Memorandum

Re: Cottonwood Crossing Car Wash Site Plan Comment Responses (PR-2021-005816)

This memo outlines the responses and changes made to the Cottonwood Crossing site plan amendment for development of a car wash at 10084 Coors Boulevard NE based on comments reviewed at the December 15, 2021 DRB meeting.

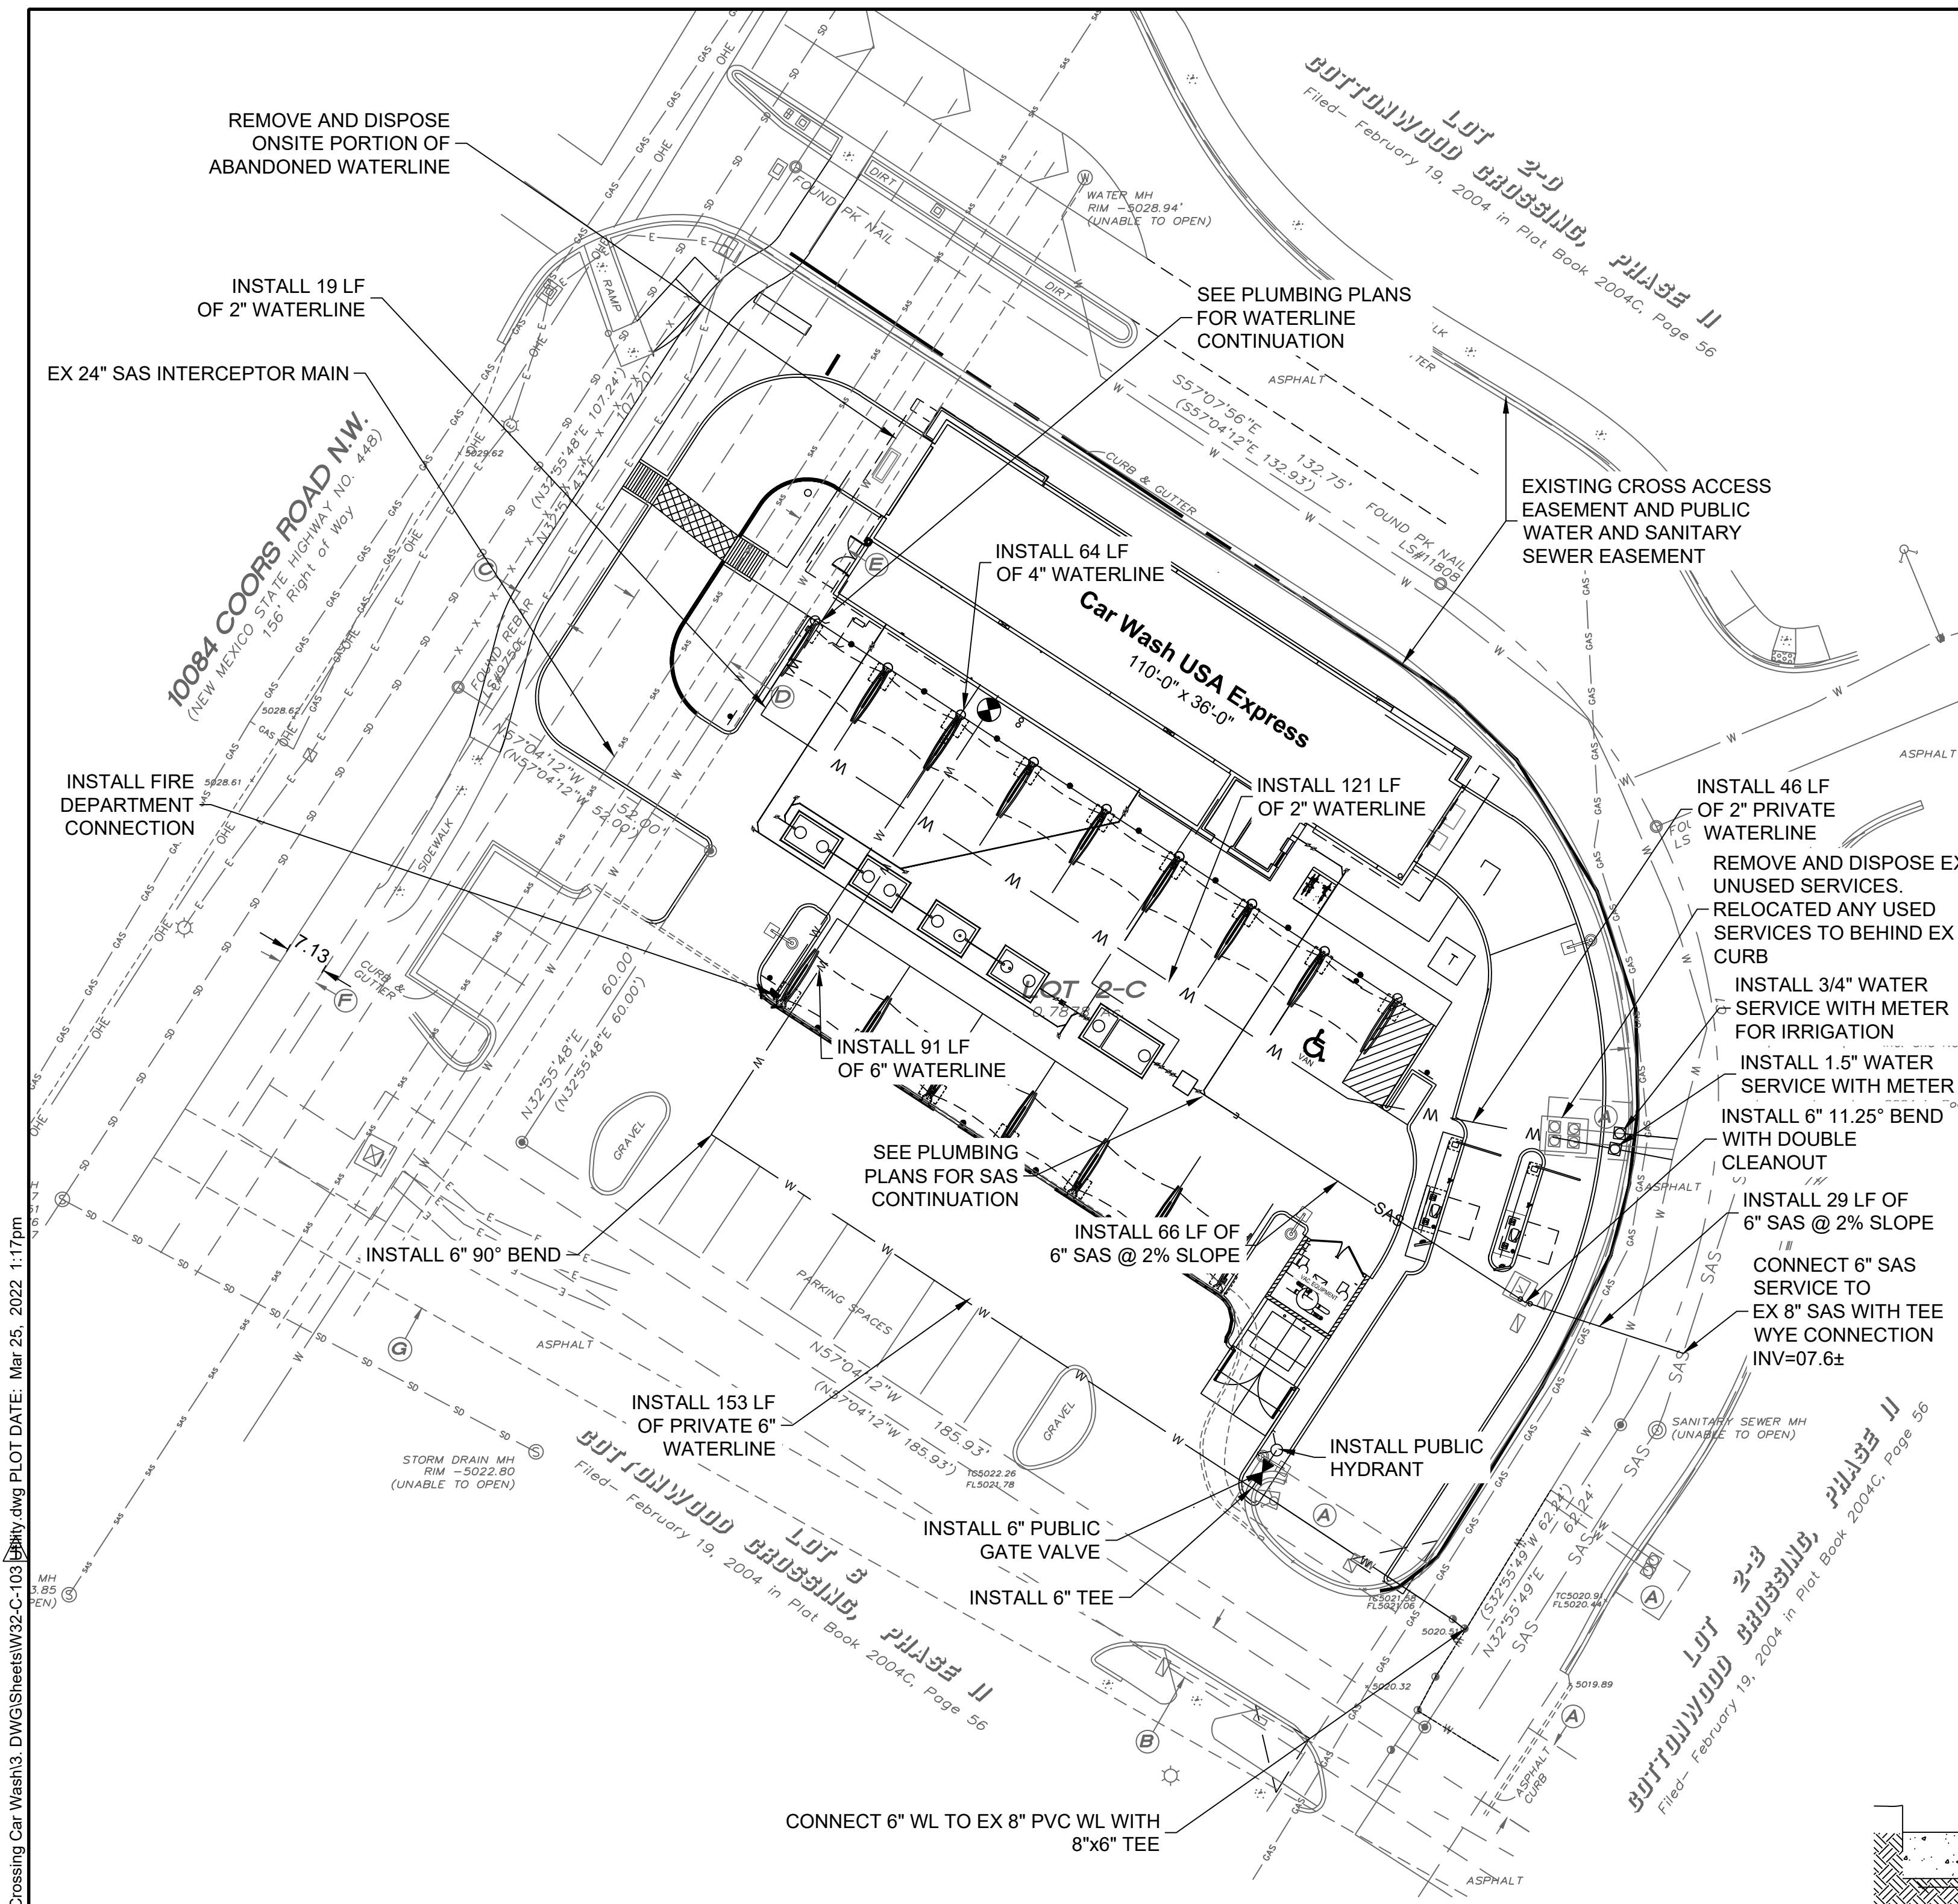
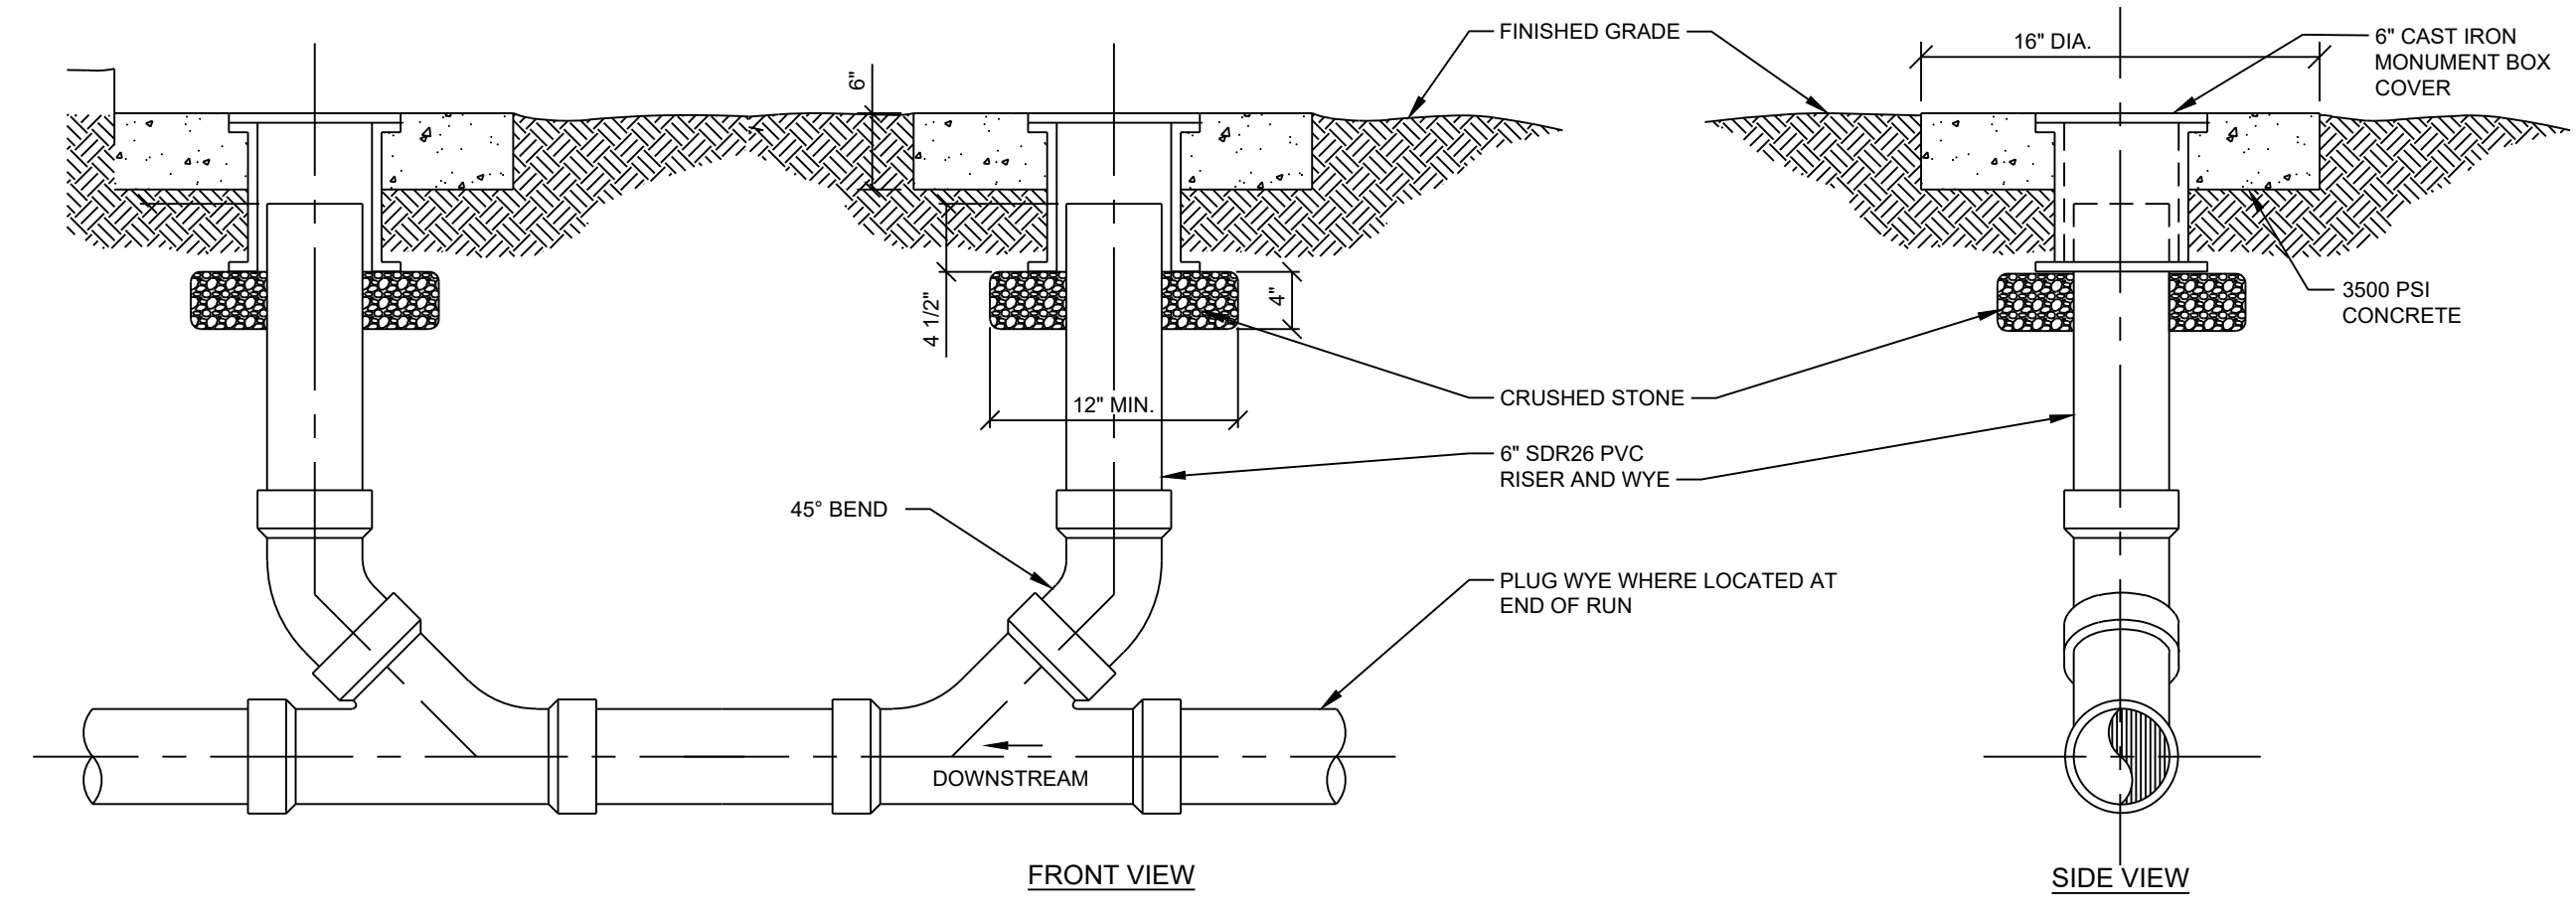
1. The encroachments on the public sewer main and easement described at sketch plat have not been addressed.
2. Call out the 24-inch interceptor main on the north side of the site as well as labeling the easement for this main. The below described encroachments shall be removed from the plan sheets within the easement. This is main is critical infrastructure and the requirements must be met.
The 24-inch interceptor main has been called out on the utility plan.

3. What are the 4 meter box looking items conflicting with the proposed domestic service location? What is the dashed rectangle in this area depicting? If the meter is not within an easement, dedicate an easement over the proposed meter location. Unused services shall be removed as described in the availability statement.
Removal and/or relocation of these meter boxes are shown on the utility plan, as noted.

6. Pro Rata:
 - a. Pro rata is not owed for this property.
7. Utility Plan:
 - a. Provide a utility plan that indicates the location of proposed services.
An updated utility plan has been included with this supplemental submittal.
